| Application number: 2026/92391   |                                                                                  |
| What is the application for?:    | Prior notification for installation of 20m monopole with wraparound cabinet, ins |
| Address of the site or building: | land off, Owl Lane, Shaw Cross, Dewsbury, WF12 7RH                               |

## User comments

Title: 250 PROPOSED SITE ELEVATION

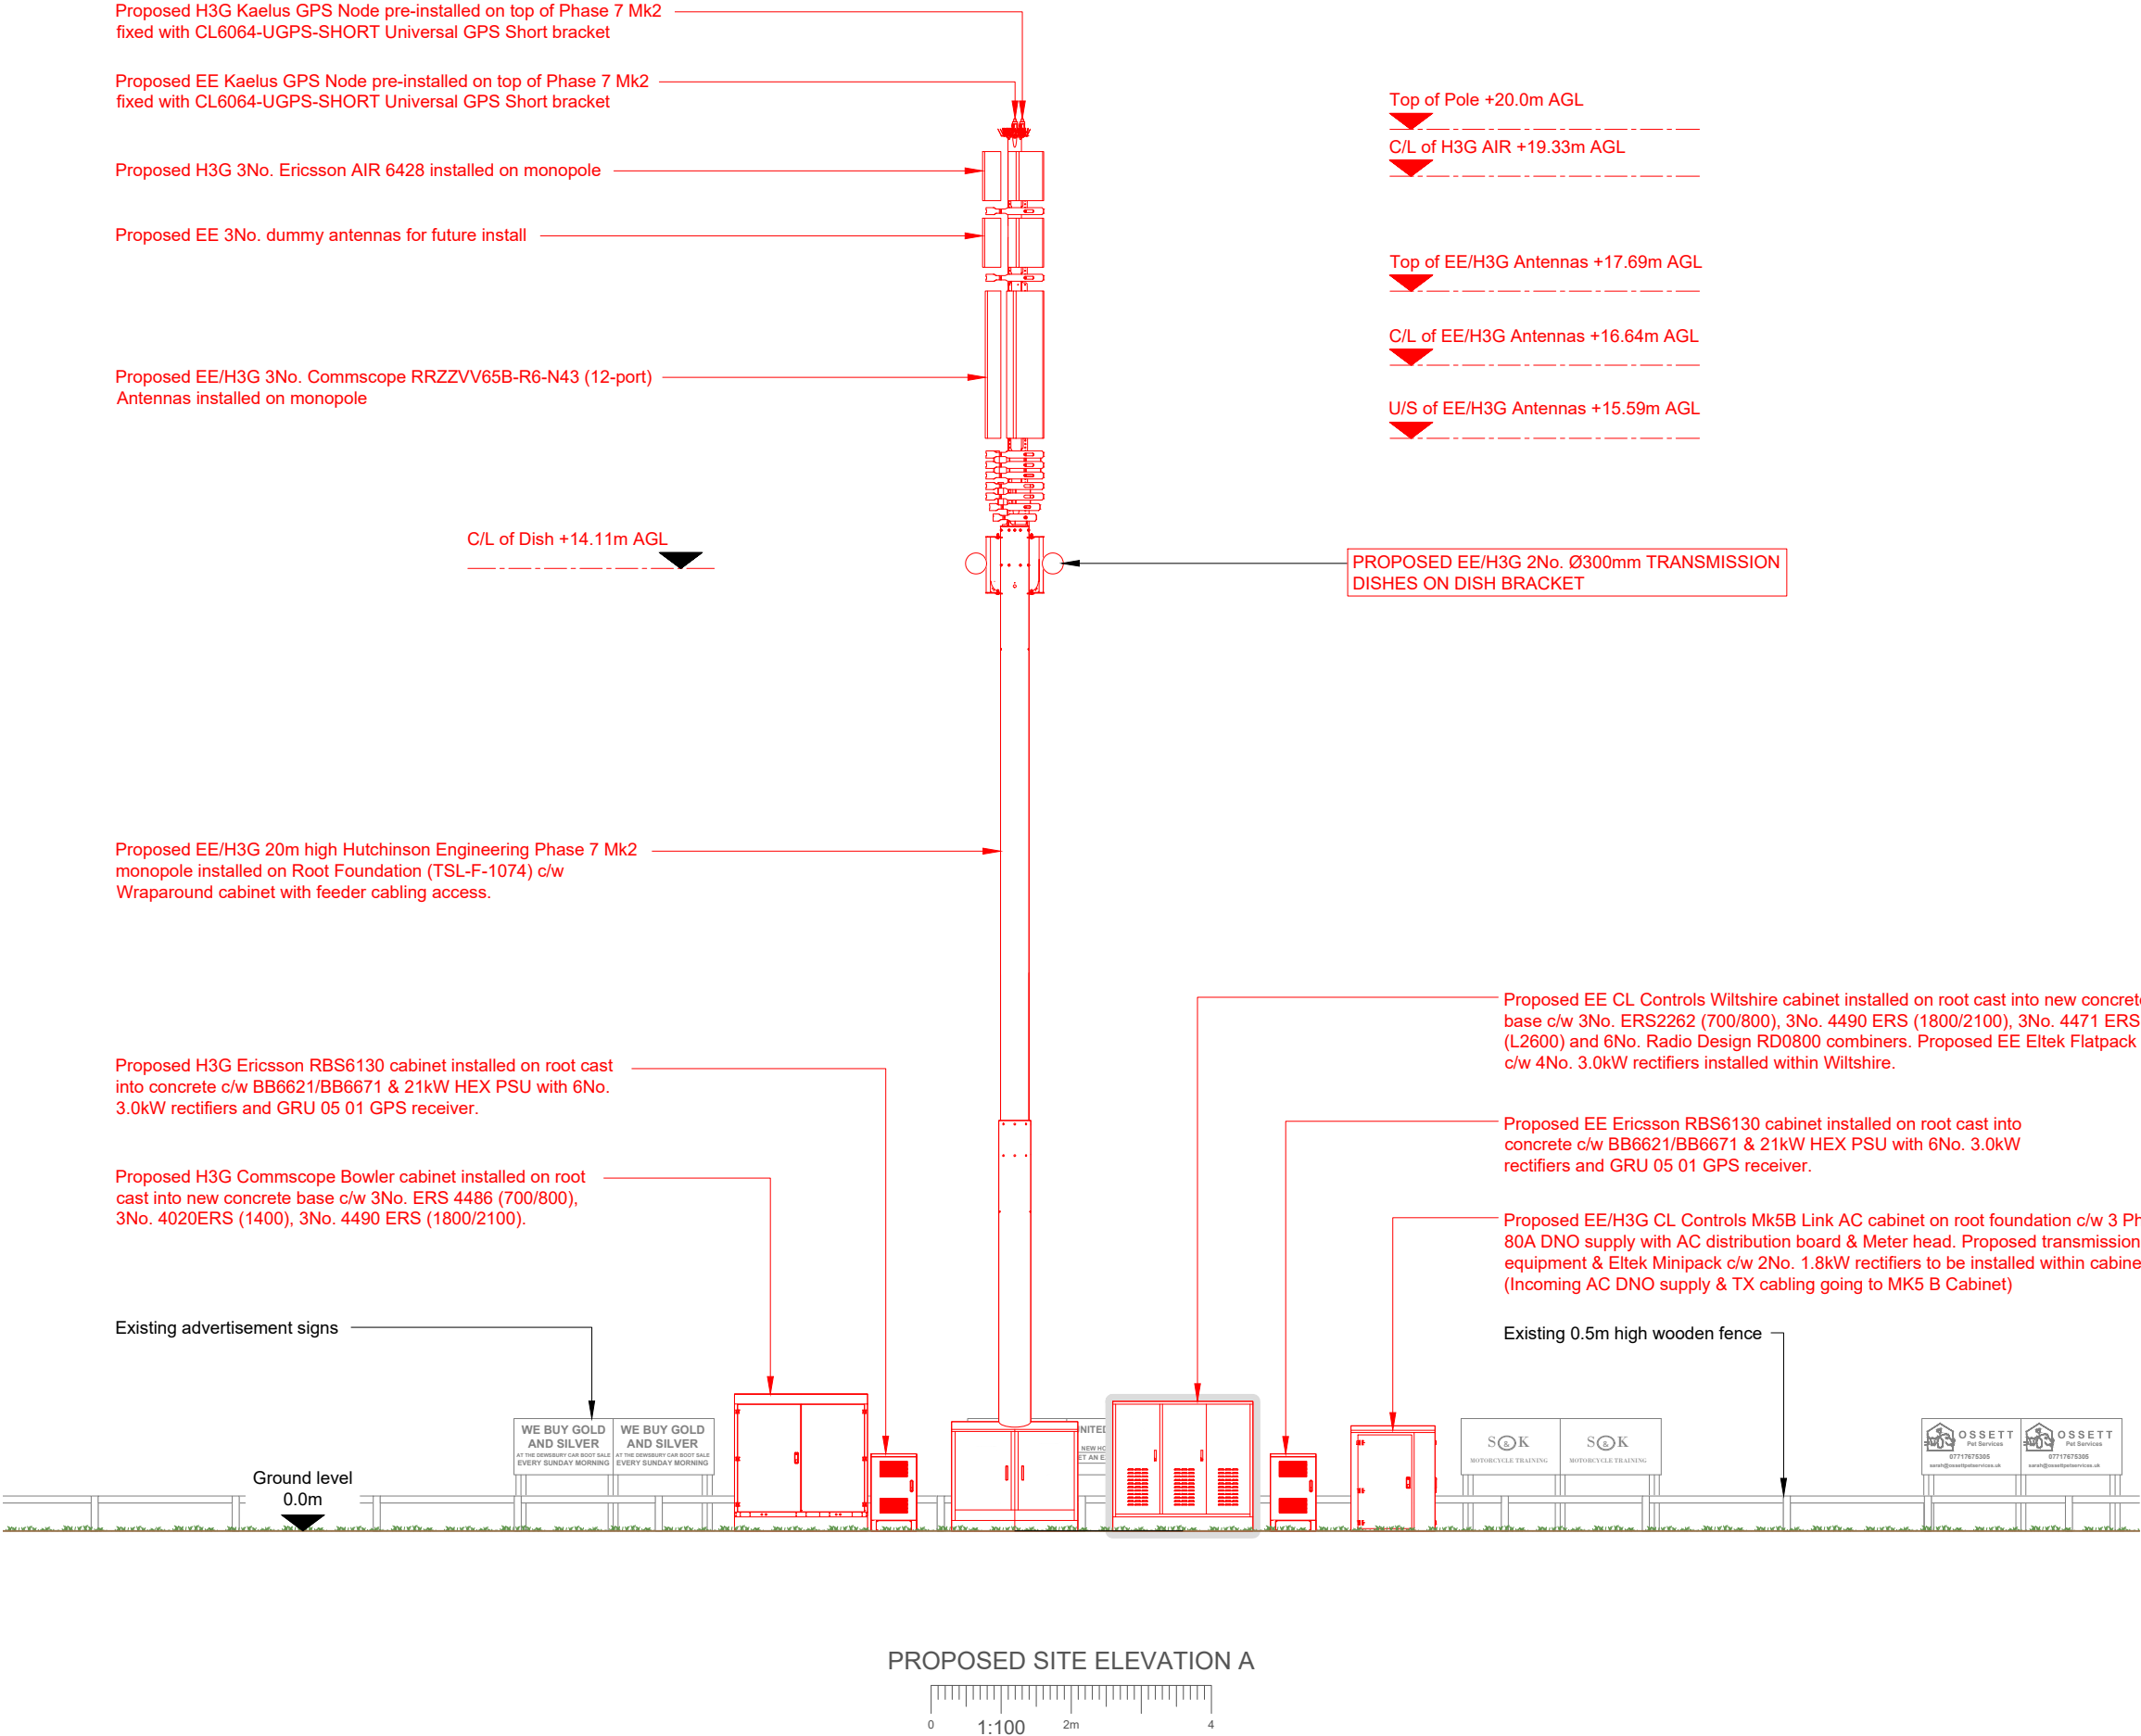
| <p>The location proposal for this Pole will cause a significant visual change to the area. Although there is reference to an 8M tree this would pale to insignificance against the back drop of a 20M pole located at the road side less than 100m Meters from "Luxury Homes" on the amberwood estate and the new estate opposite. Those who purchased homes on the leading edge of both luxury developments were not consulted prior to purchase that a digital mast could be located within their view, this should be considered. The presence of the pole i feel could be a distraction to drivers simply based on it's size, the road is a 40 MPH road leading to a 30mph at the roundabout and pedestrian crossing, this is a main route heavy laden with HGV traffic, a lapse of concentration could lead to severe accidents. The area has already been significantly impacted by loss of green space due to previous and ongoing developments, the areas surrounding the estates would suffer further by the erection of the digital equipment. ASB is a consideration too, the location is adjacent a car park that is not covered by a firm surface, the area is stone and rubble, this could give rise to ASB in the way of individuals using stones to try and hit the pole or the arials sited on it, this is adjacent a main carrigaeway which could lead to RTAs and damage to passing vehicles. Equipment of this type should be in a more dicreet location not adjacent main roads and opposite luxury housing developments, if the masts are feeding chickenley then a location closer to the area of coverage should be considered giving consideration to it's size and appearance.</p> |     |
